**Consultation Response from Mike Hibbert,
KC Waste Strategy(Refuse & Recycling)**

2022/93932 Crown House, 12, Southgate, Huddersfield, HD1 1DE

Date Responded: 27/02/2023

Responding Ref: WPS 23-007

Bin Store Front Elevation
1 : 50

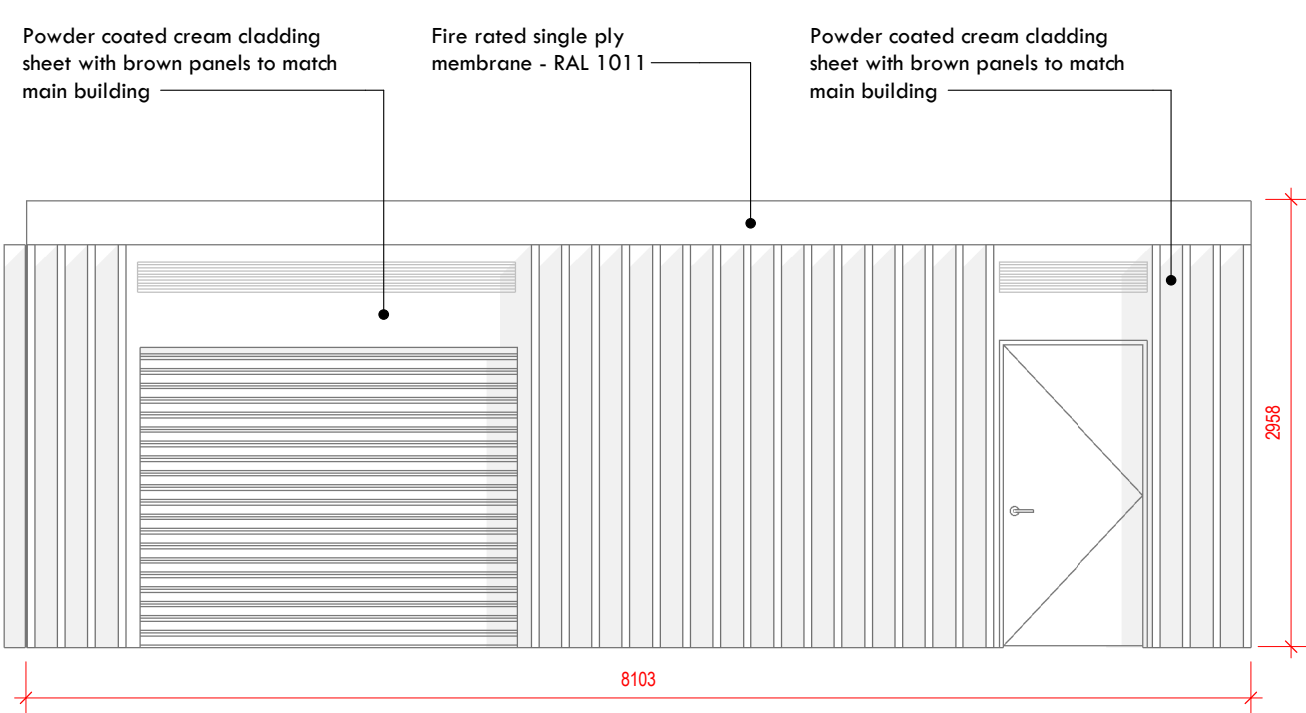
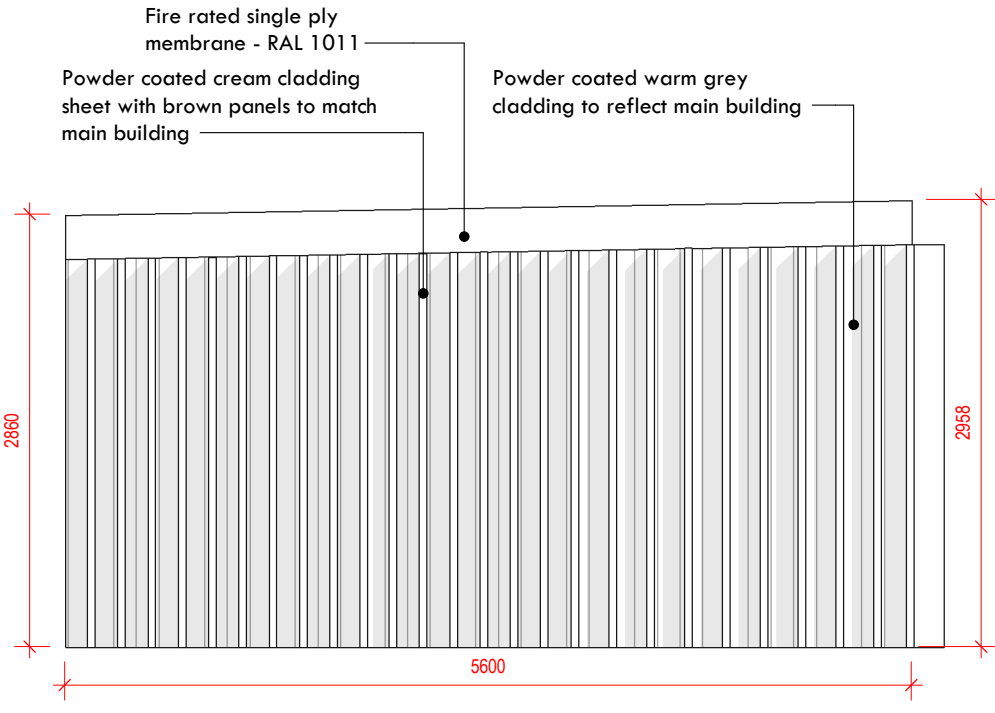
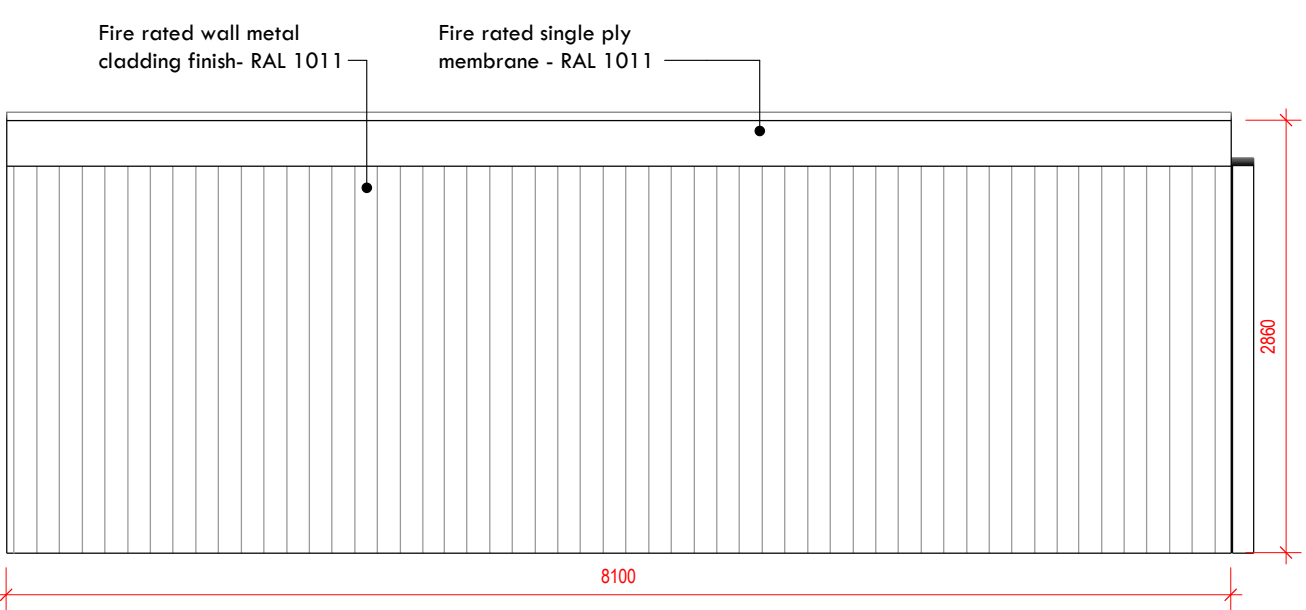
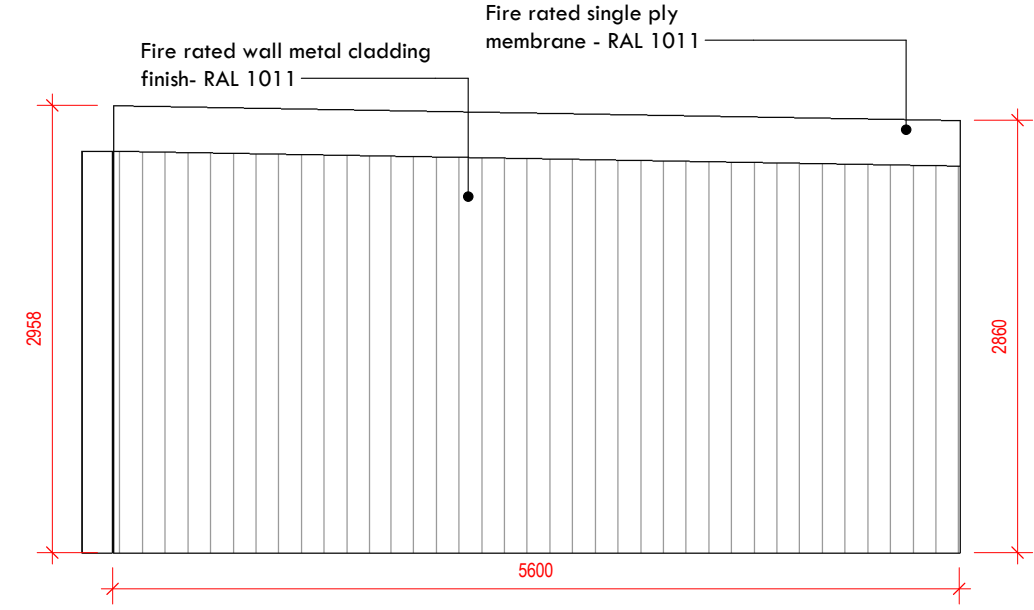
The applicant has submitted a Proposed Basement & GF Plan Ref P-101 Rev A Dated 12/12/2022 that shows a 28m² Bin Store.

- For 198 apartments the recommended waste storage provision is 35,640ltrs (180 ltrs x198) for both residual and recycling bins. Appropriate waste storage provision would be 32 X1100ltrs wheeliebins. It may be unrealistic to store this number of bins and provision of a compactor skip, or large containers maybe more appropriate. The applicant may have baseline data from other similar developments that can be used to refine the likely waste arisings.

- Guidance indicates the floor space for a 1100ltr wheeliebins is 1575mmx1190mm with space to manoeuvre the bins within the store so the bin store dimensions would depend on configuration within the store. Additional information is required detailing waste storage, containers, capacity and design of the waste storage compound including, screening, surfacing and security. Appropriate standards are detailed in the Kirklees Waste Management Design Guide 2020. Bin store surfaces should be durable and waterproof enough to withstand heavy duty cleaning such as power washing.

- Further information is requested on the location of bin presentation points for collection and the arrangements in place to get the bins to presentation points from the bin store

- The waste store should be secure to prevent theft, unauthorised use/ fly tipping or rough sleeping. If the doors to the bin store are to have a keypad to secure access these details will be required by the collection staff.
